7th February 2012

EXISTING TELECOMMUNICATIONS SERVICES (7 RAILWAY ST, CHATSWOOD)

Landscape Master Plan

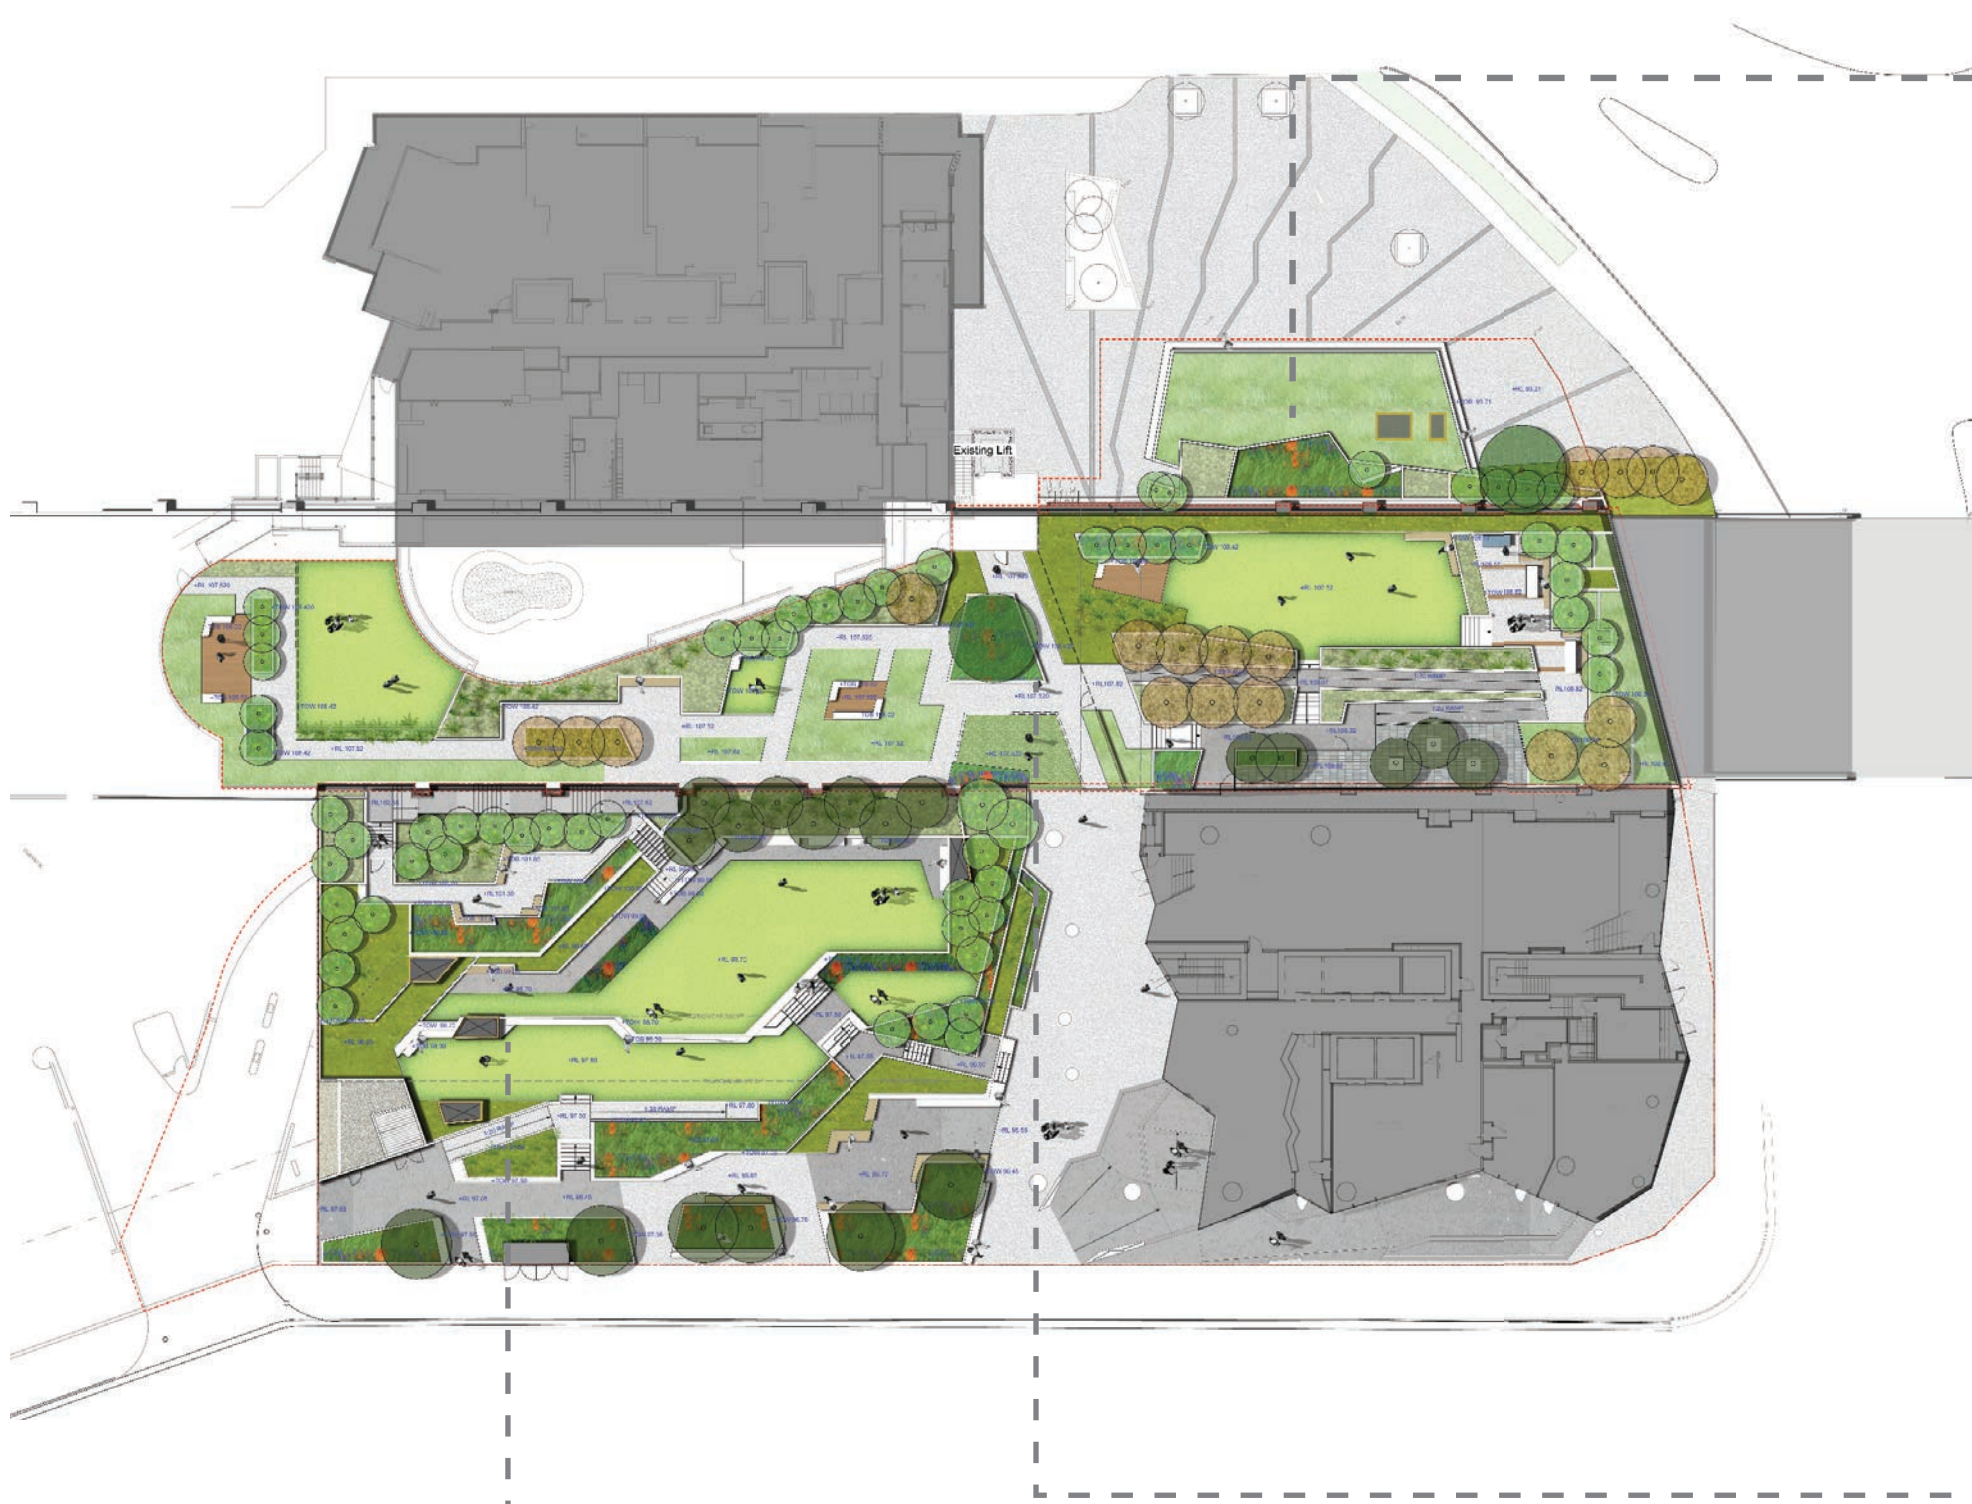
The proposed planter/tree zone on Railway Street will have a major impact on the existing in-ground services, especially on the Telstra underground network.

From our previous work in this area, this Telstra network includes major Sydney-Brisbane fibre links from the nearby Chatswood Telephone Exchange.

The proposed tree zone would require the relocation of the Telstra network including major inter-city fibre links, man-holes and a bank of 9x100mm telecommunications conduits from their standard allocation as determined by the Streets Opening Conference into a compressed shared trench with Ausgrid High Voltage Cabling.

The loss of available verge width for services would leave insufficient space for these major authorities' network services to share a common trench. There are extreme cost penalties for any damage to these major Telstra links due to loss of telecommunication services.

All stakeholders/authorities impacted by the proposed tree planting zone on Railway Street need to be fully consulted prior to proceeding with any works.
